**Addendum No. 2**

RE: Contract # C204793

**Rockingham County (BR-0041, BR-0043)**

BRIDGE 78001 OVER US-29 ON SR-2817 AND BRIDGE 780151 OVER US-29 ON US-158.

REVISIONS						SHEET NO.
NO.	BY:	DATE:	NO.	BY:	DATE:	S-04
1			3			TOTAL SHEETS
2			4			48

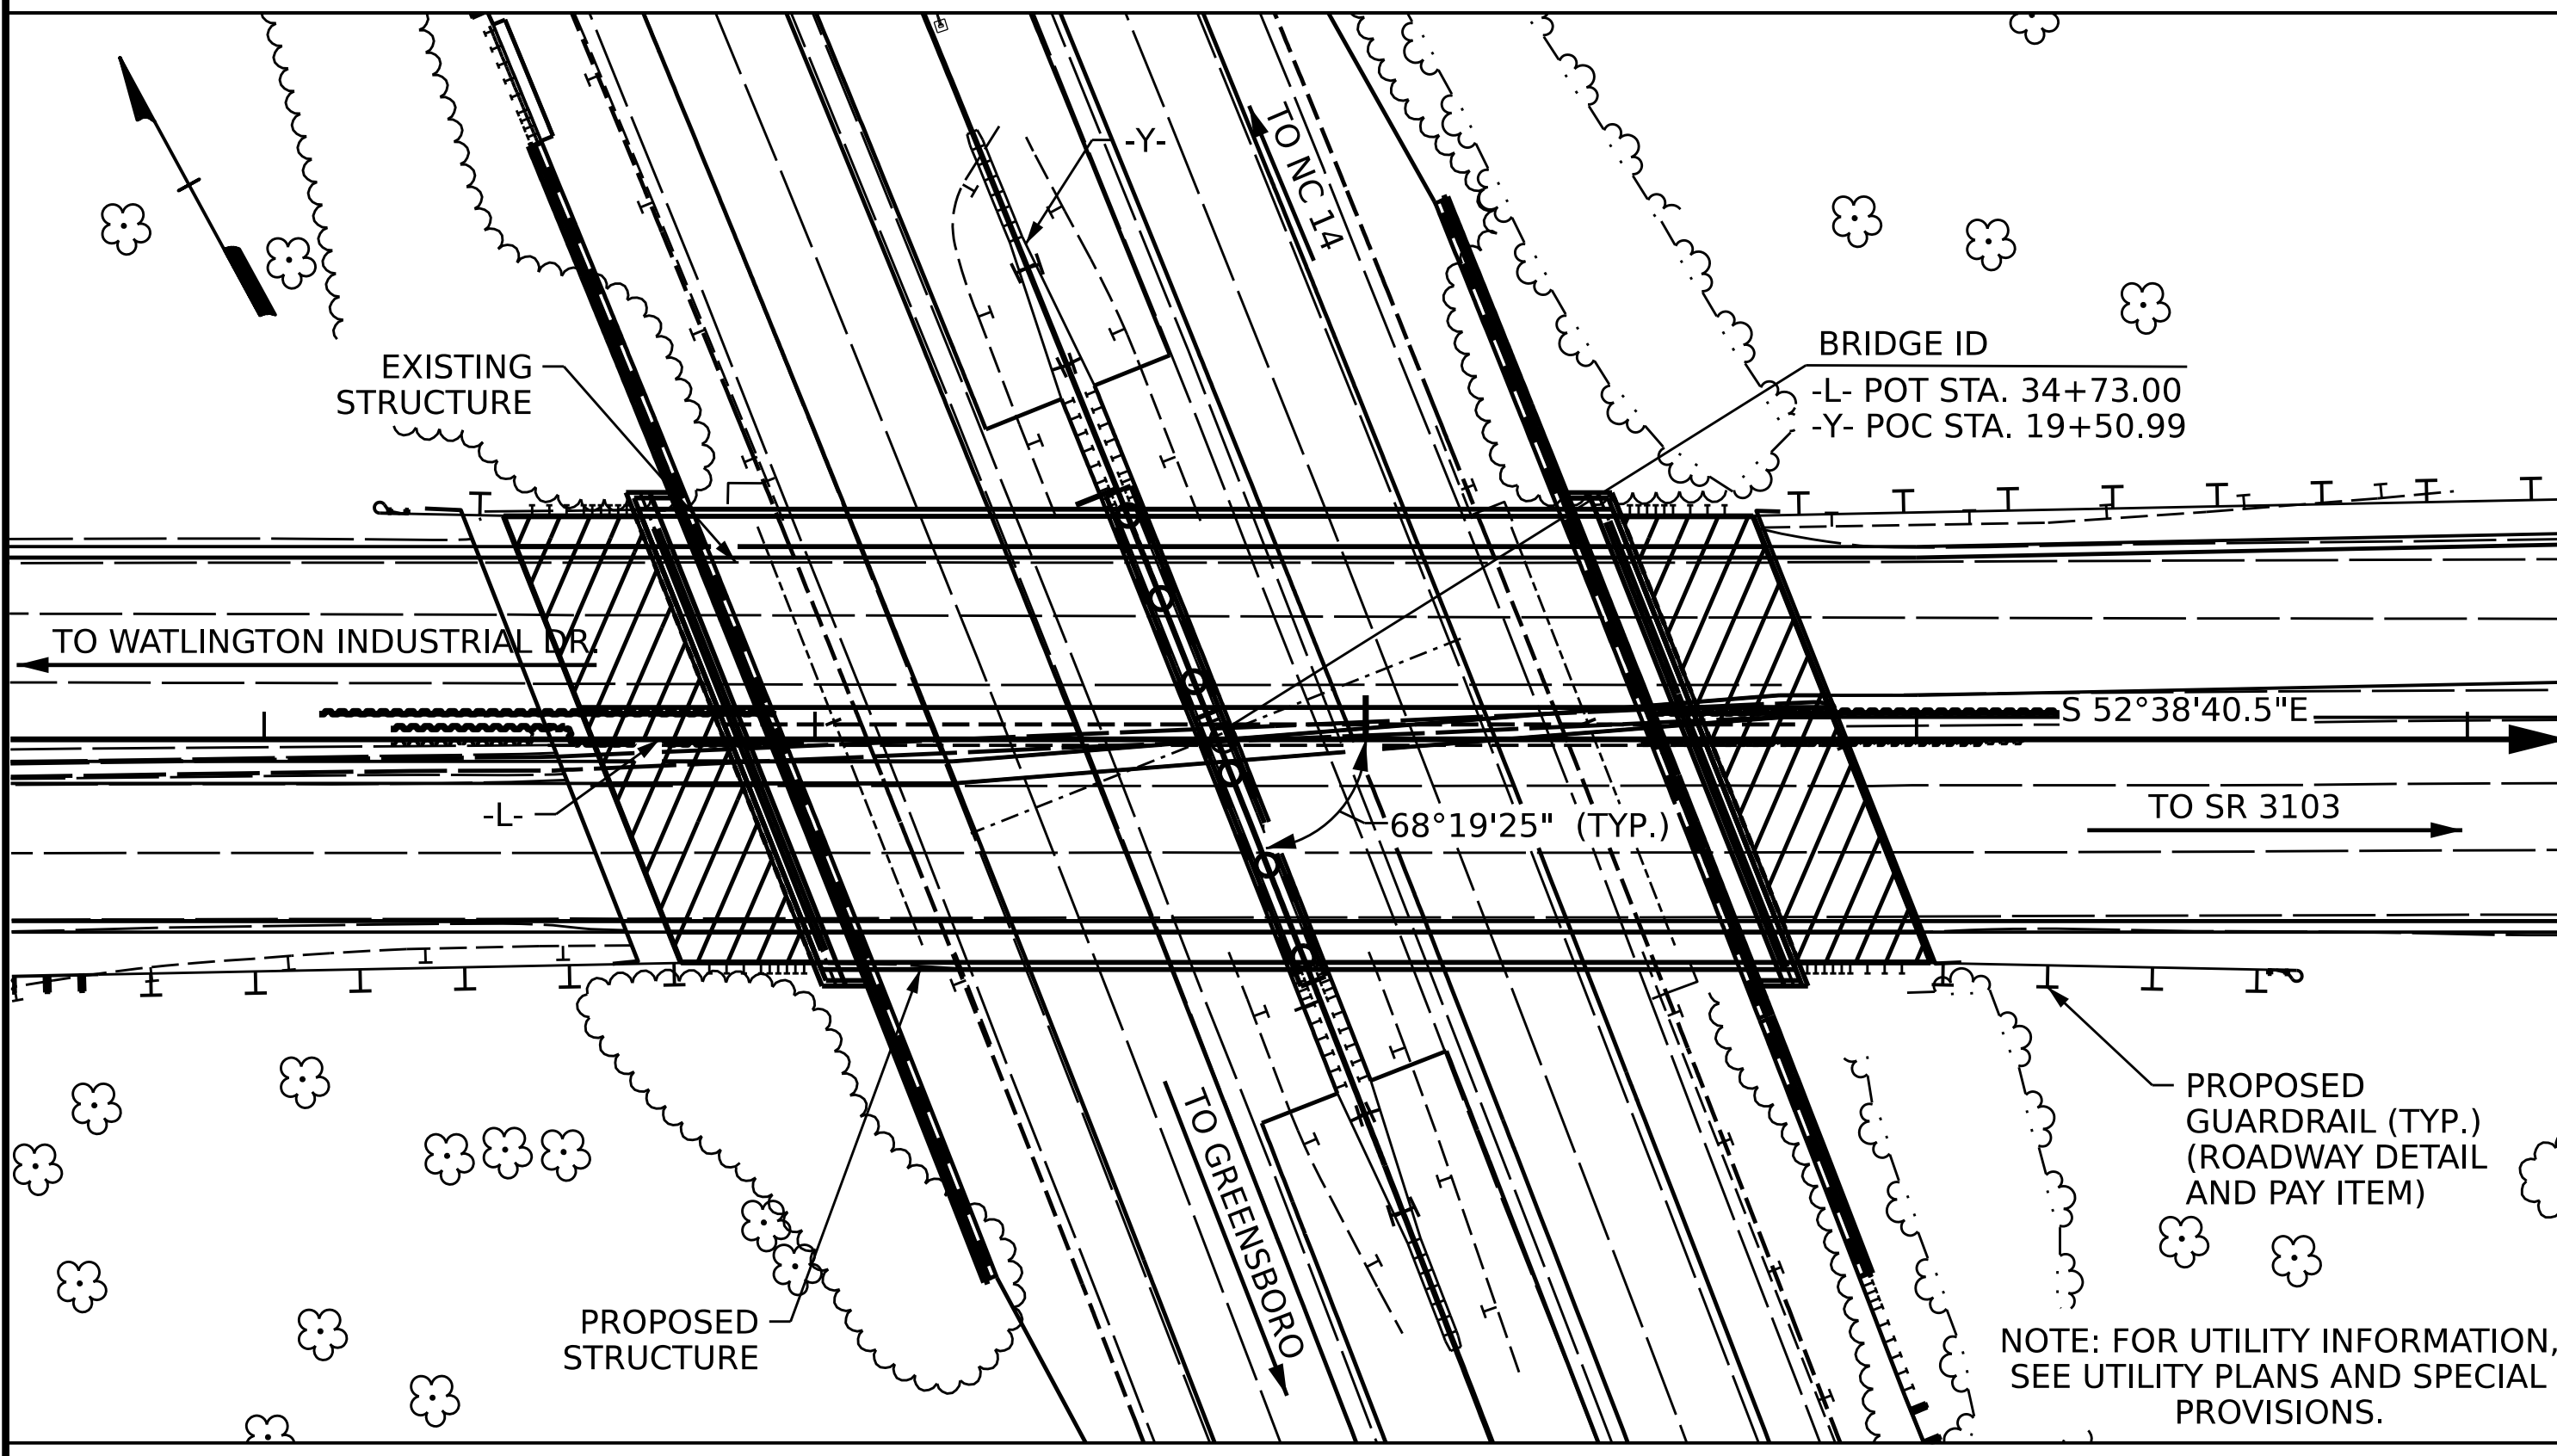
Sheet No.	Revision
S-04	Bill of Material updated to reflect quantity changes below.

<u>Item</u>	<u>Description</u>	<u>Old Quantity</u>	<u>New Quantity</u>
0235-8105540000-E 411	3'-6" DIA DRILLED PIERS IN SOIL	22 LF	220 LF
0237-8105640000-E 411	3'-6" DIA DRILLED PIERS NOT IN SOIL	220 LF	22 LF
